From: Graham Middle [clocktowerhouse@btconnect.com]
Sent: 25 January 2012 15:50
To: Anita Gardner
Subject: RE: CL/11/11/DOC - Compliance with condition 6 of CL/11/10
Attachments: SITE PLAN SP01B Model (1).pdf

Waterford House (formerly Merrie Gardens), Clapham, Worthing, West Sussex, BN13 3UY
Planning Application : CL/11/10

Waterford House (formerly Merrie Gardens), Clapham. Worthing, West Sussex, BN13 3UY
Planning Application : CL/11/10

Waterford House (formerly Merrie Gardens), Clapham. Worthing, West Sussex, BN13 3UY

AMENDMENT 'B': JANUARY 2012
ADD: Existing Tree Information Updated - GRM
AMENDMENT 'A': August 2011
ADD: Boundary Tree Planting Information - GRM

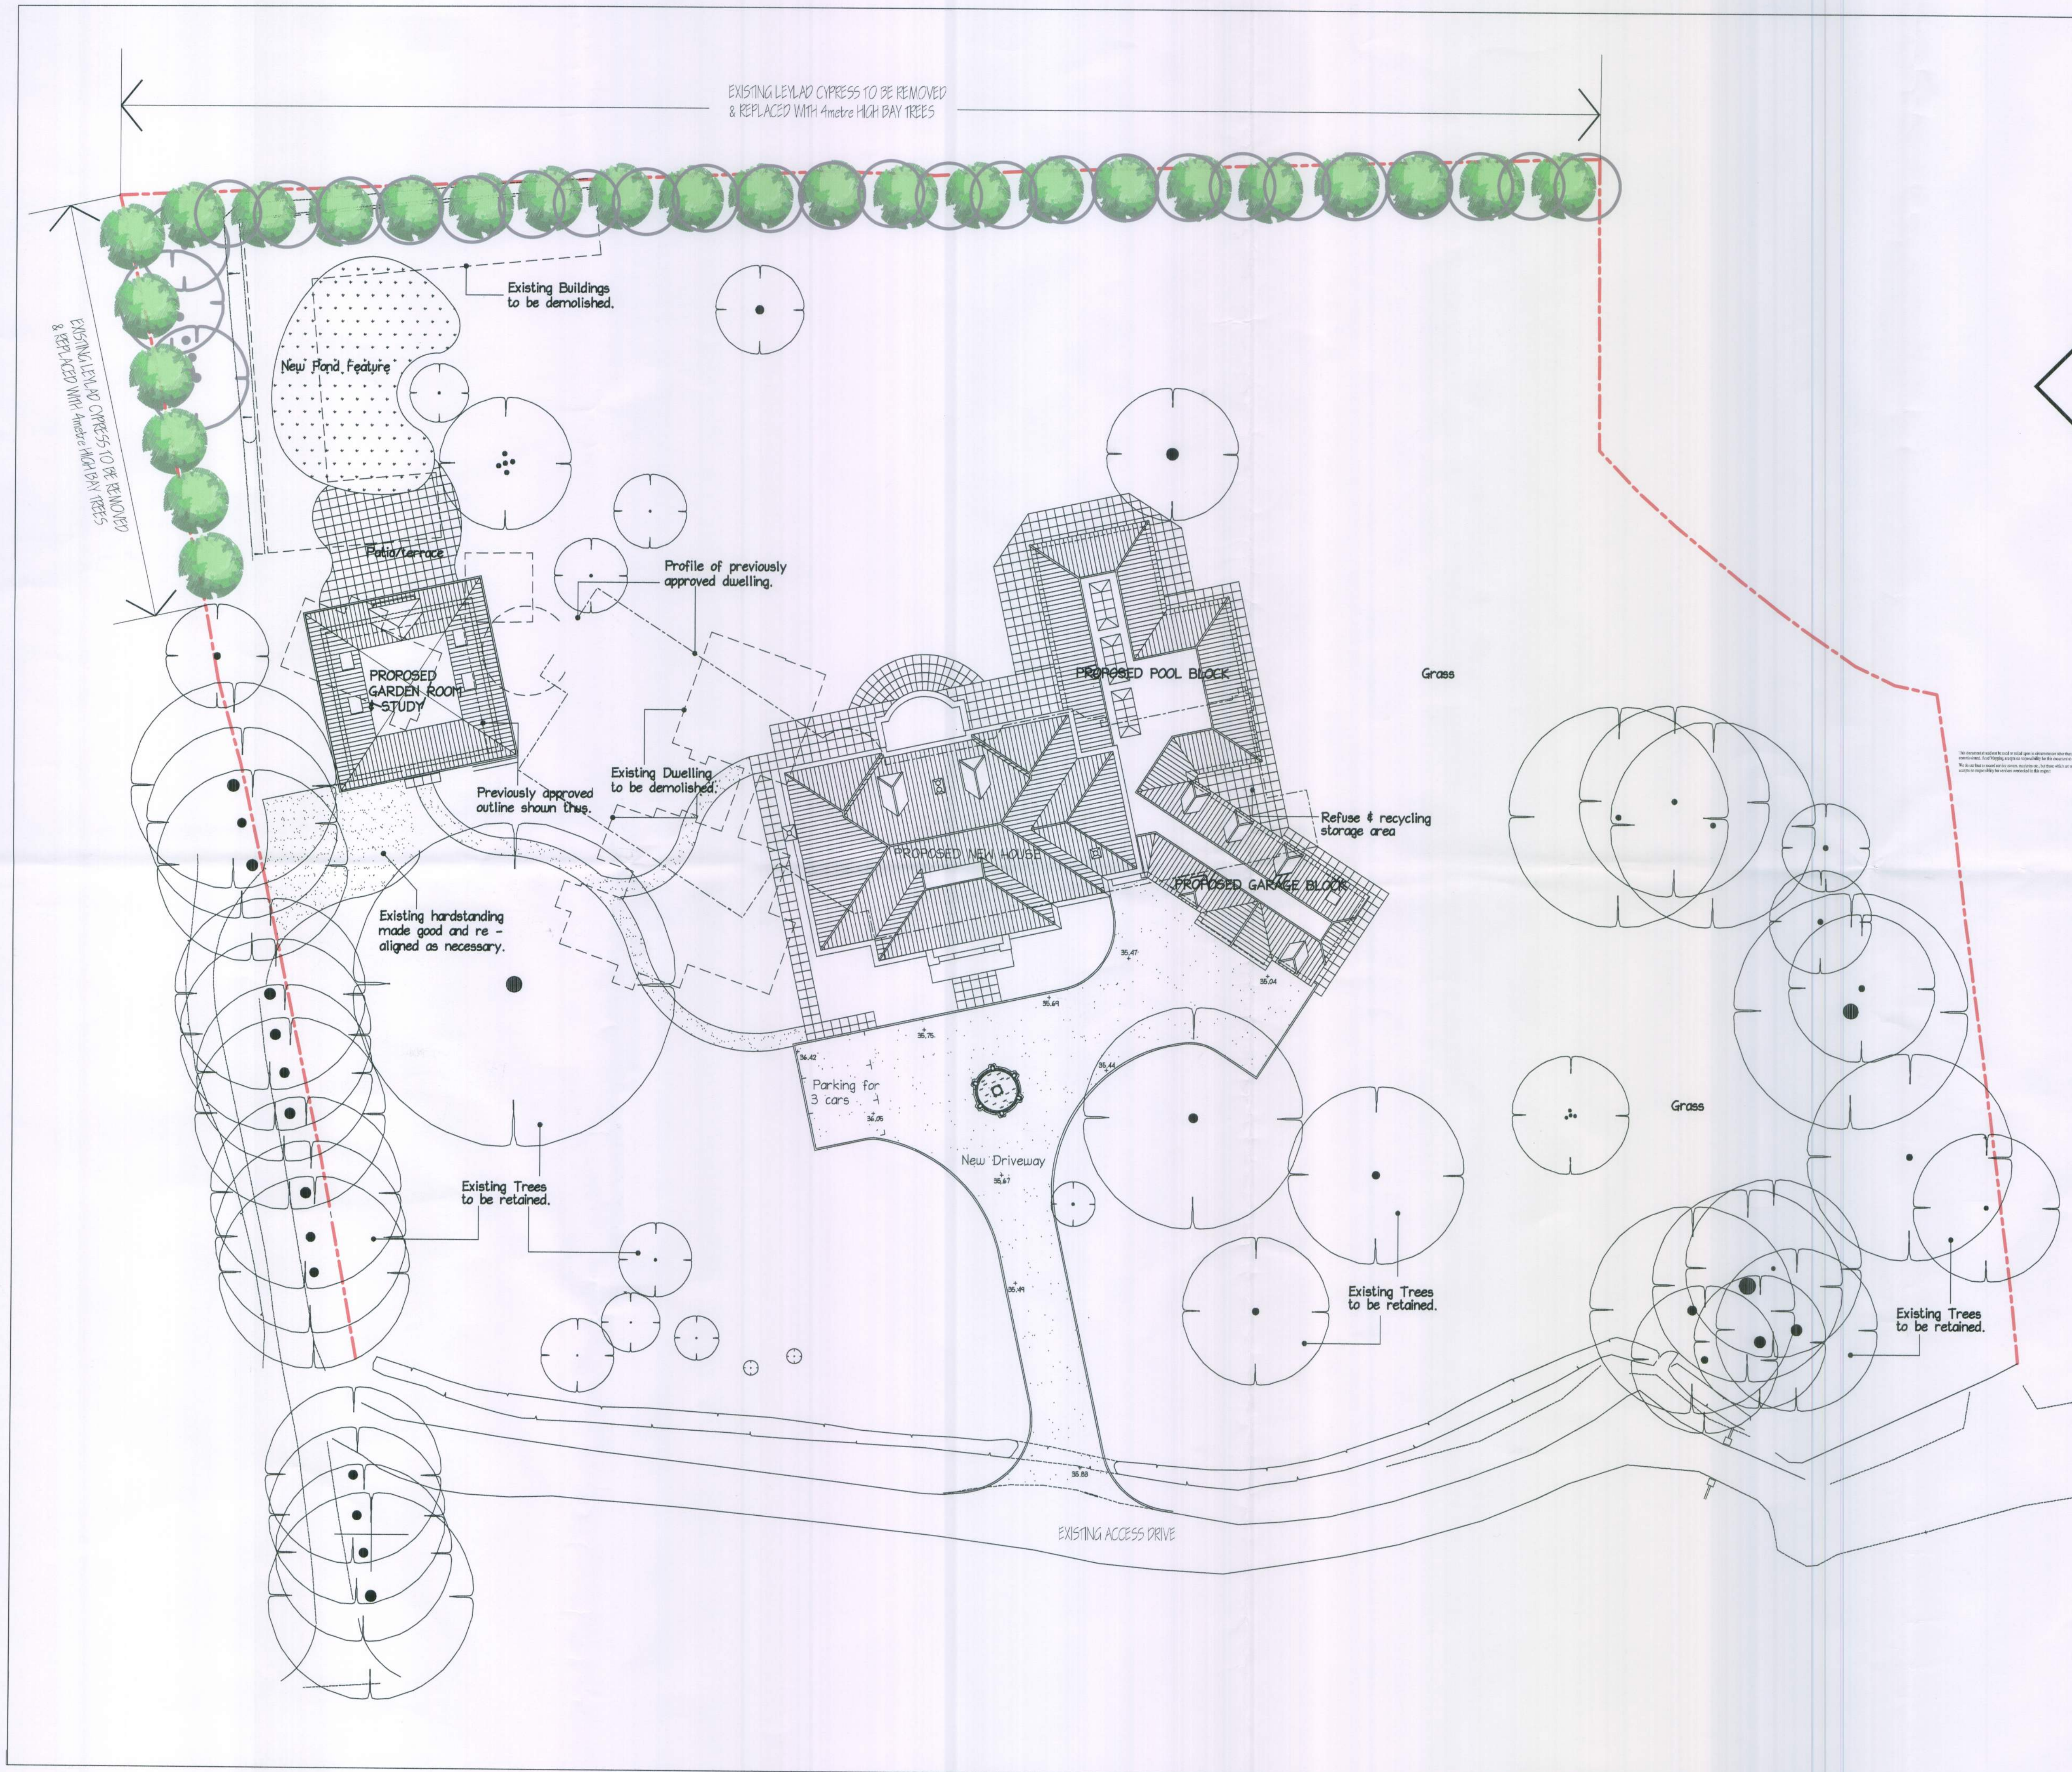
I refer to our earlier conversation with regard to the difference between dwg. SP01A & Arbtech's TPP drawing relating to existing/to be retained trees, together with both drawings not providing any information relating to the land within the site boundary located to the West of the existing drive which you advised formed part of the original planning application.

I have adjusted dwg. SP01A to match Arbtech's TPP drawing, however I cannot get hold of Mike Hartnett and none of the original Architects drawings in our possession clarify the land, trees or boundary line to the West of the drive, but can confirm the landscape works to this area have been completed.

Please advise how you wish me to progress or is the attached amended drawing SP01B acceptable?
